## DEPARTMENT OF PUBLIC WORKS

TO: All Staff  
FROM: Public Works Plan Review Team  
DATE: June 22, 2021  
SUBJECT: BL-21-00014 Frosty Pines

The Public Works Department has reviewed the Request for Boundary Line Adjustment Application. The applicant needs to be aware of the following:

2
OF
2

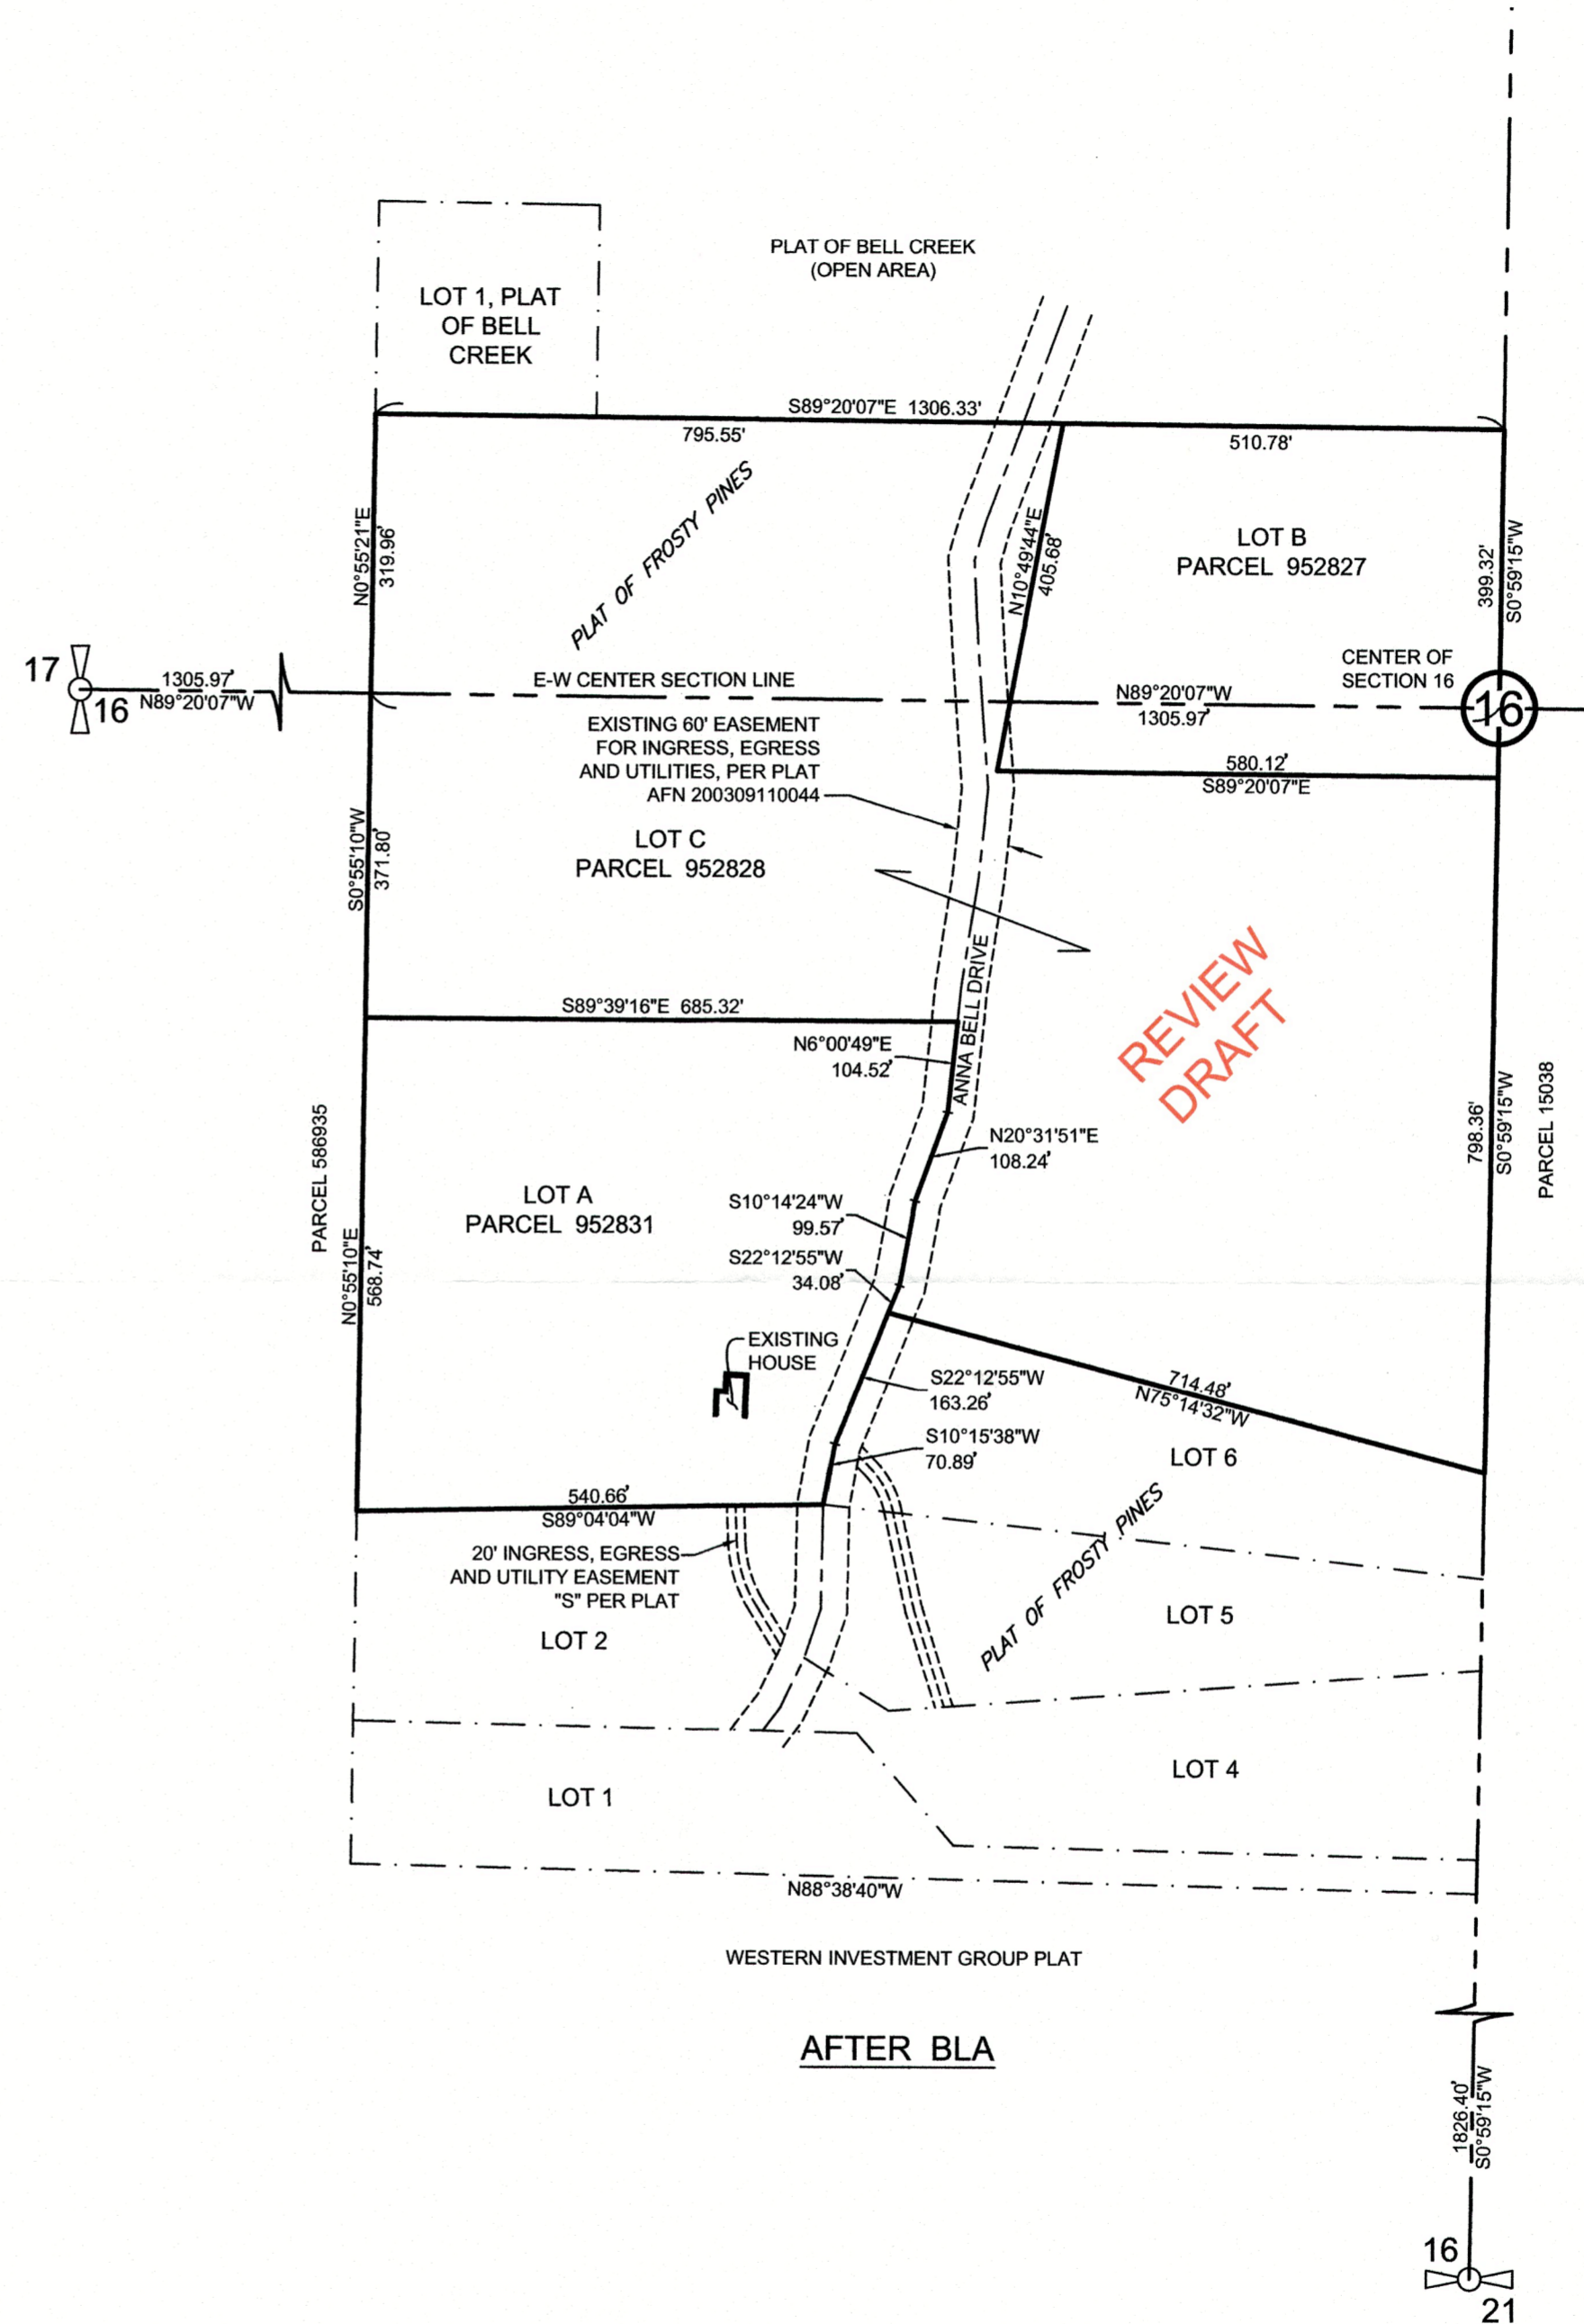
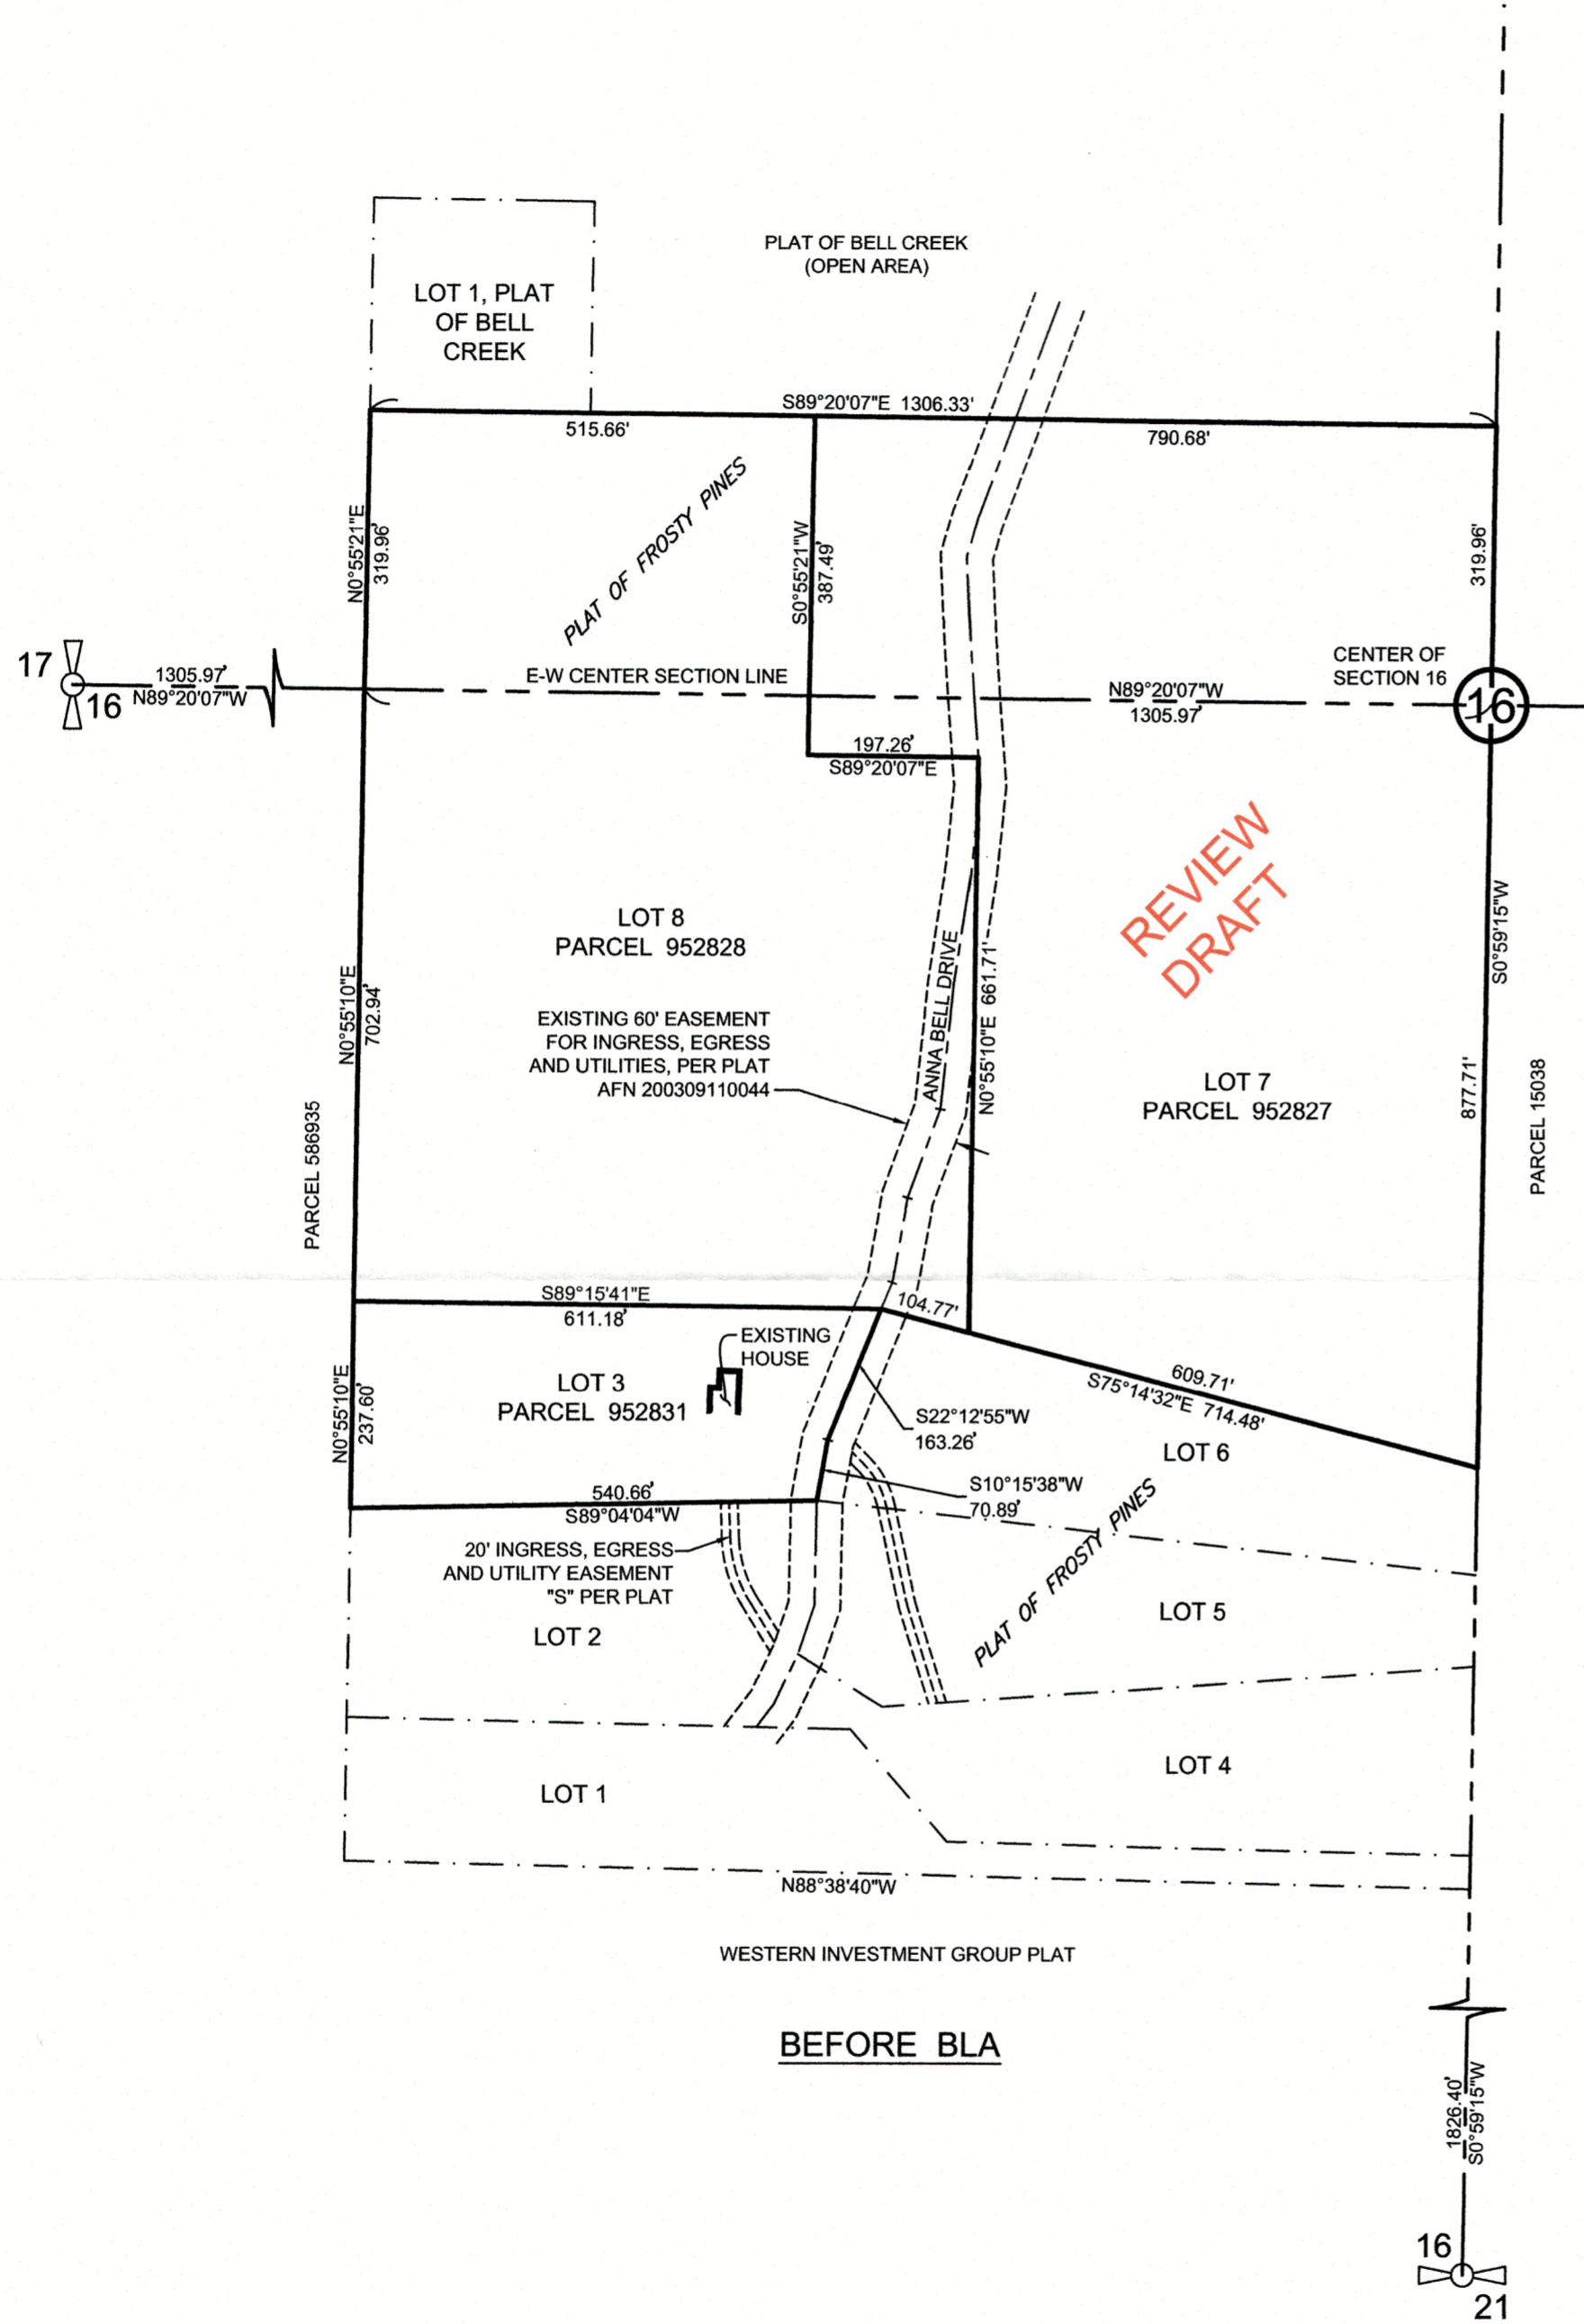
1. Show found and set property corners. At a minimum, the new division line shall be staked in the field.
